Technical Note

Project: The Eagle at Barrow, Clitheroe

Subject: LLFA Objection Response

Client:	Fence Gate Limited		
Project No:	08336	Version:	A
Document Ref:	08336-TN-02	Author:	Andrea Nelmes
Date:	10/07/2026	Approved:	Alison Caldwell

PJA Ref 08336	Scale @ A1 1:200	Date 07/01/2025
Drawing No. 08336-WR-0500		Revision P2
Primary Contact kerry.whitehouse@pja.co.uk

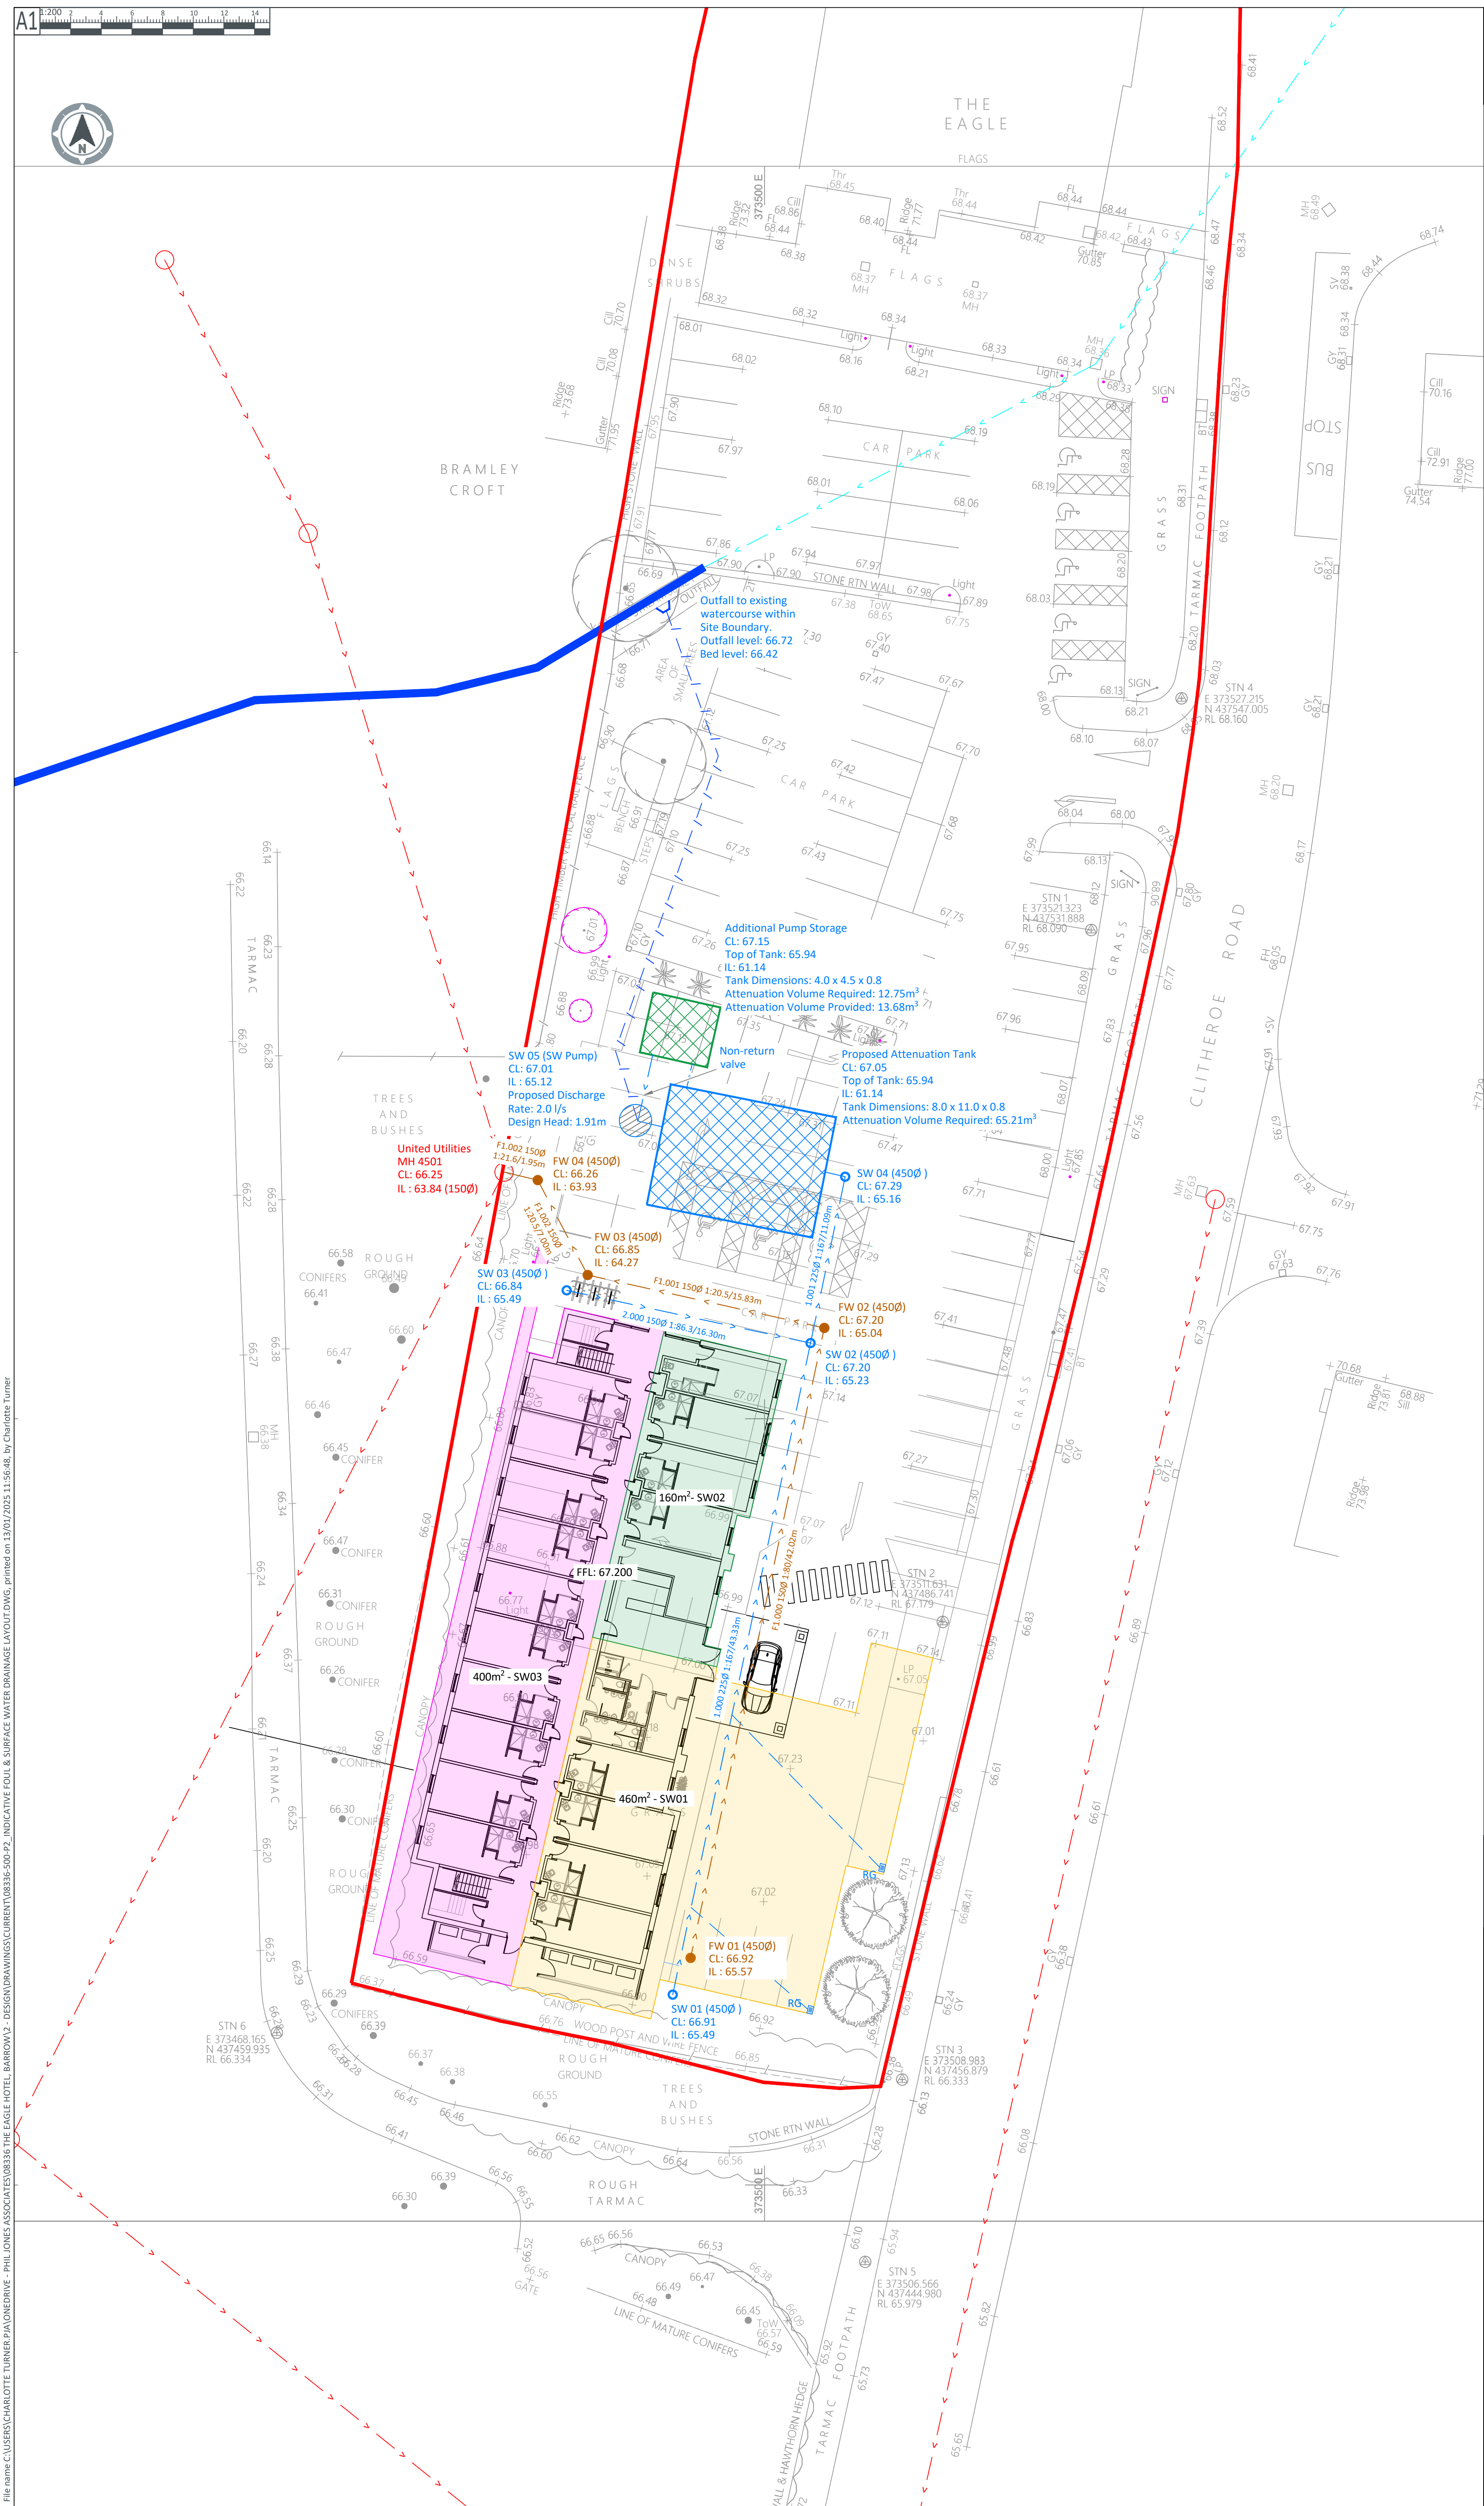
1. **Provide evidence to demonstrate why pumping is required** to drain the development site in line with Standard S12 of the Defra Technical Standards for Sustainable Drainage Systems.

Standard S12 of the Defra Technical Standards for Sustainable Drainage Systems requires that pumping should only be used to facilitate drainage for those parts of the site where it is not reasonably practicable to drain water by gravity. The applicant has not provided robust evidence as to why pumping is required to drain the development site, nor provided evidence as to why the proposed drainage system cannot be drained by gravity. This is sufficient reason in itself for a refusal of planning permission.

2.3.3 In accordance with Standard 1, the proposed drainage strategy discharges attenuated surface water runoff to the adjacent ordinary watercourse (Priority 3) via a pumped rising main, rather than by gravity to the existing 150 mm diameter United Utilities combined sewer (Priority 5), as illustrated on Figure 1 and Appendix B. Accordingly, the proposed strategy achieves a significantly higher priority runoff destination than the only available gravity alternative.

- 2.3.5 By comparison, directing surface water runoff by gravity to the existing 150 mm diameter public combined sewer (refer to Appendix C for asset mapping) would unnecessarily introduce additional hydraulic loading to existing combined sewer infrastructure during rainfall events and, during periods of network exceedance, has the potential to increase the frequency and/or volume of Combined Sewer Overflow (CSO) operation together with the associated risk of sewer surcharge.

- 2.3.6 Although such a solution may be physically achievable, it represents the lowest priority runoff destination within Standard 1 of the National SuDS Standards and has the potential to increase the volume and frequency of Combined Sewer Overflows (CSOs) and the risk of sewer surcharge during periods of intense rainfall. Any resulting flooding from the public sewer network would also present a significantly greater environmental and public health risk owing to the potential presence of foul sewage, whereas the consequence of a temporary pump failure would be limited to the controlled storage of clean surface water within the site's designated low point.
